**Harnett County**  
420 McKinney Pkwy  
LILLINGTON, NC 27546  
Phone:  
Fax:

**SUBJECT: SFD2106-0027**  
**SINGLE FAMILY DWELLING**

Here are the results of all Inspections located at **140 THORNTONS CREEK DR:**

Inspection Type: ROUGH IN SFD CRAWL  
Scheduled Date/Time: 7/10/2023  
Completed Date/Time: 7/10/2023  
Inspector: John B Kokoszka  
Result: FAIL W/ PENALTY  
Remarks:  
Notes:

ROOF PLAN

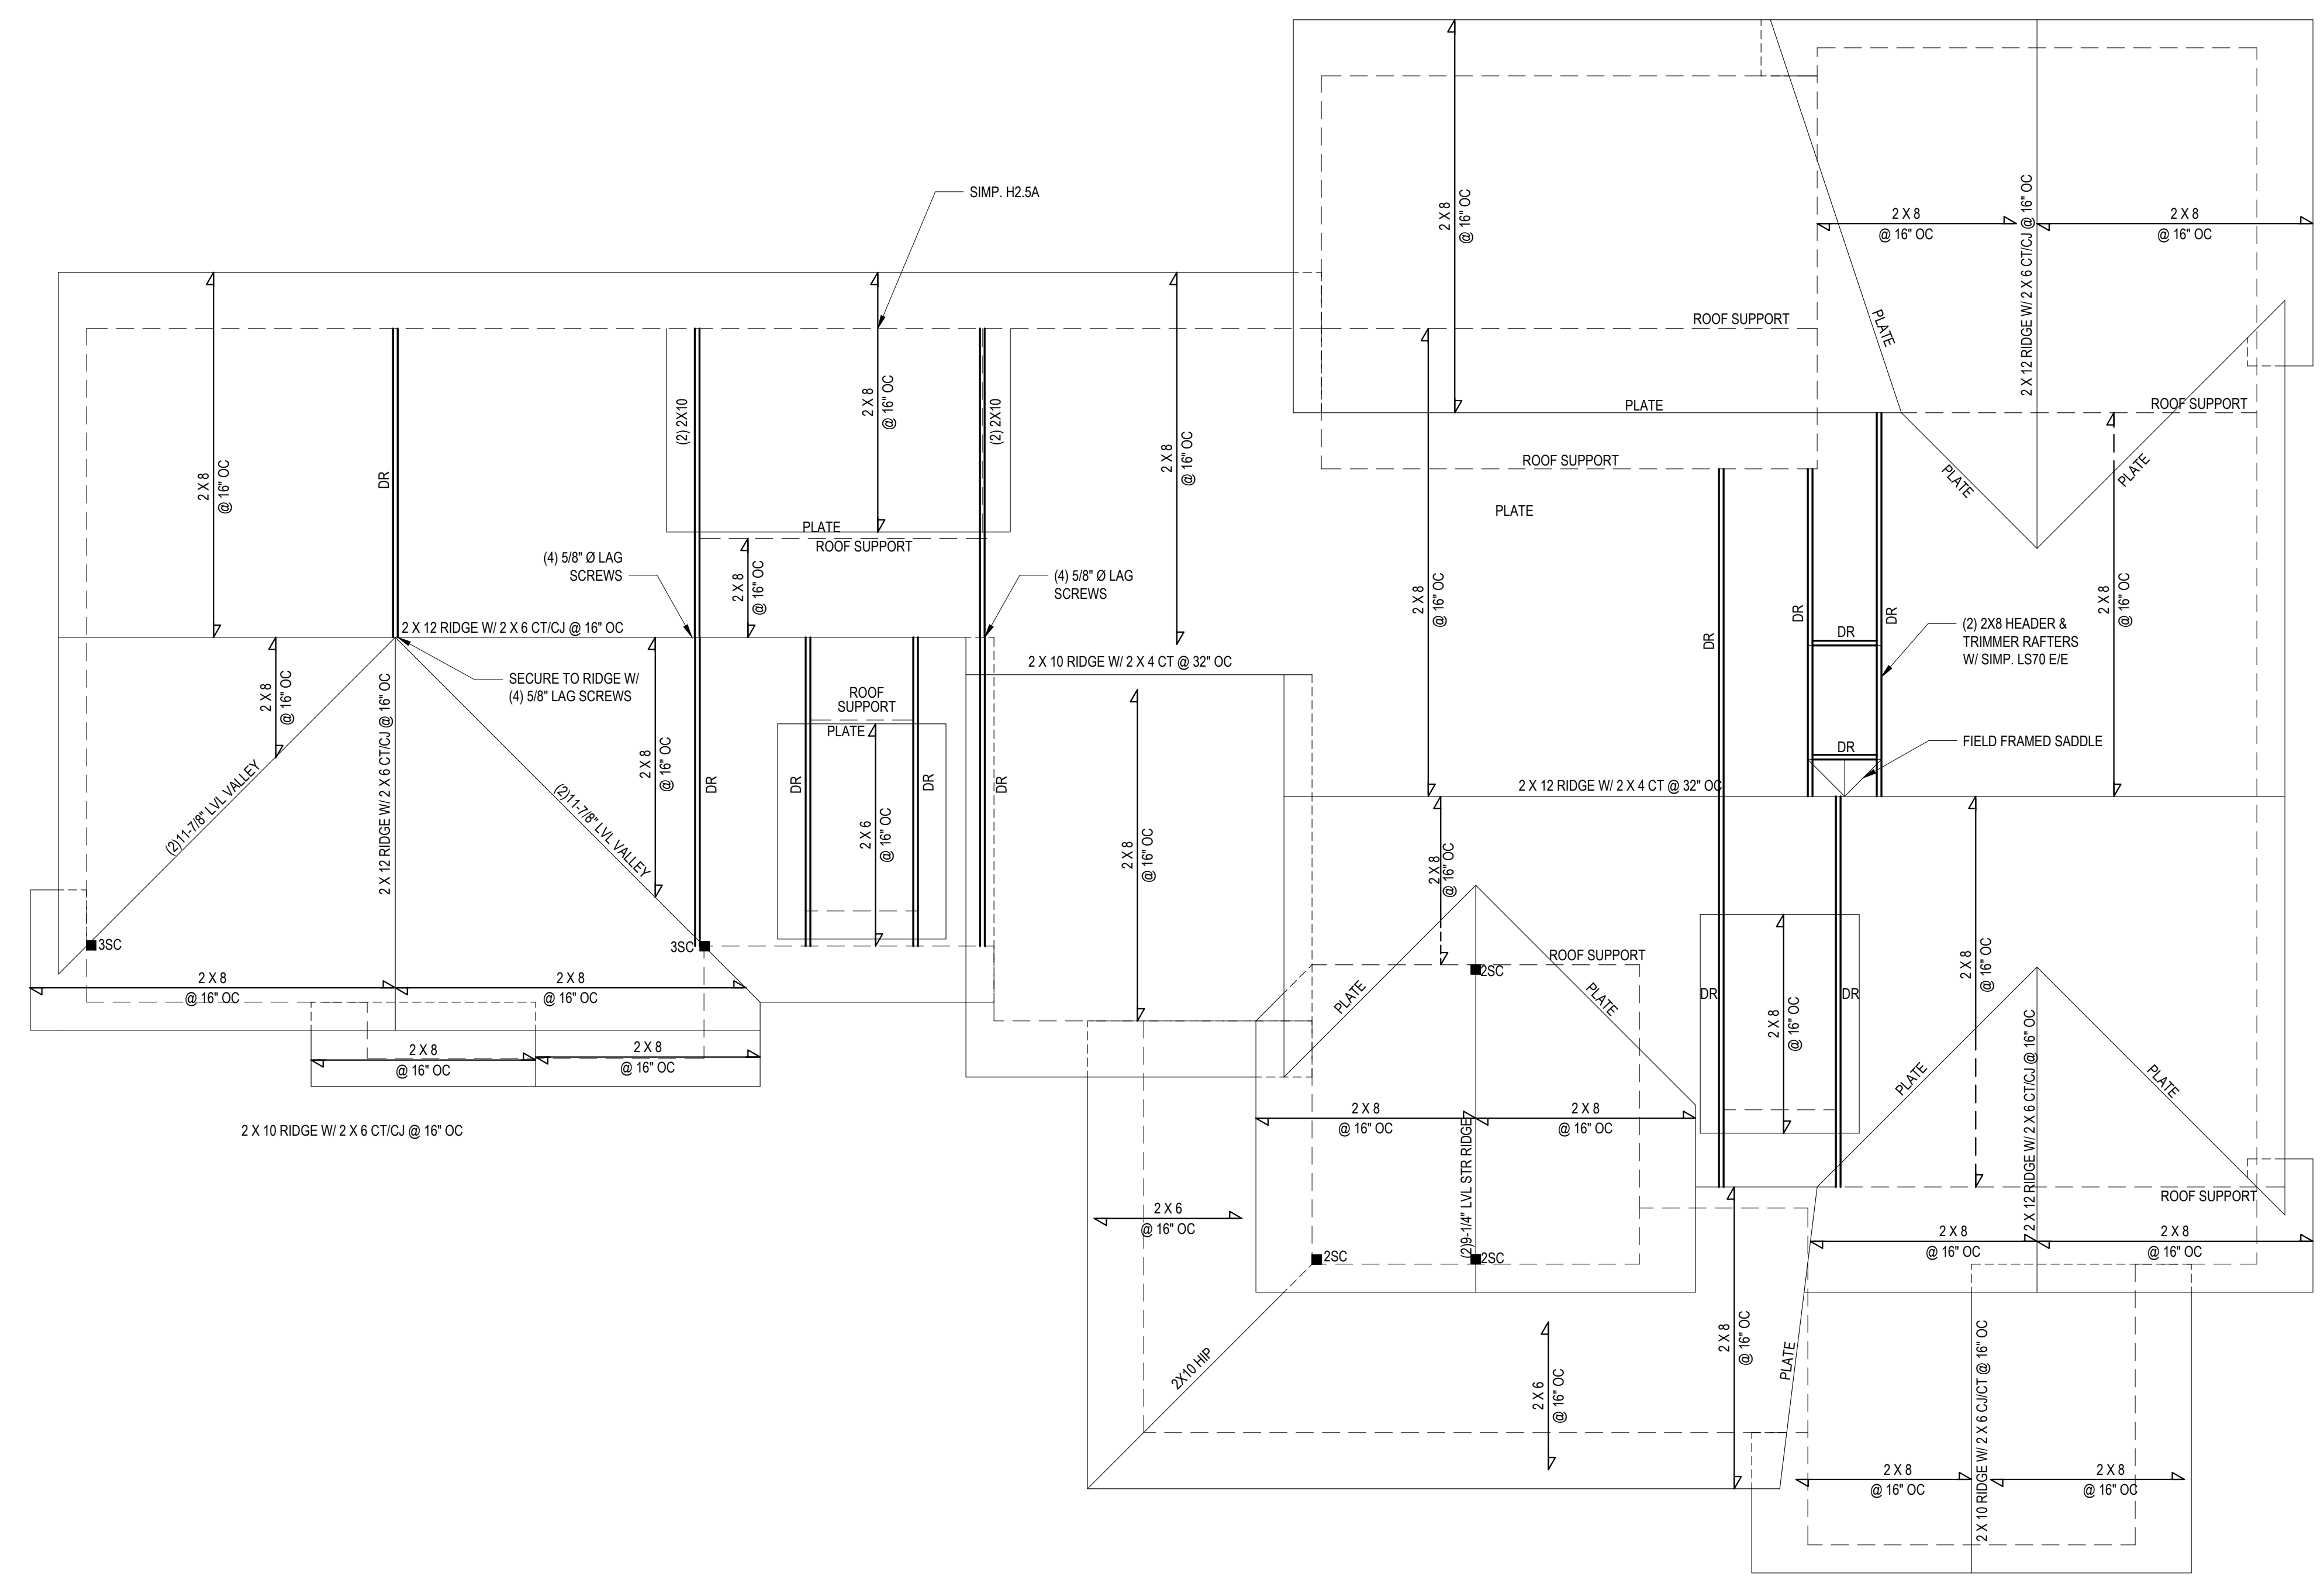
1. Portal frame bolts loose and a few anchor bolts in garage 2. Can't notch jack stud at bottom plate at portal bolt 3. Missing jack studs on both sides of garage header 4. Duct work needs to be protected at stairs 5. Mid point strap on plumbing line 6. Need approved fire stop at plumbing line in garage and missing at water closet next to garage , dryer vent pipe , left closet by stair 7. Need 100 psi on test 8. Missing king under 9 1/4 lvl per plans 9. Missing header over return and need to be boxed in 10. Missing king on fire place lvl right side 11. Notched front porch beam at kitchen window 12. Need to strap sc in front right bedroom front porch, 4sc in master 13. Need to add king on each side of master window 14. DWV no water in test 15. Air barrier need to be sealed upstairs 16. Missing window 17. Missing fire stop upstairs closet, behind shower Stopped inspection. Need to look at roof system and need layout for trusses in garage.
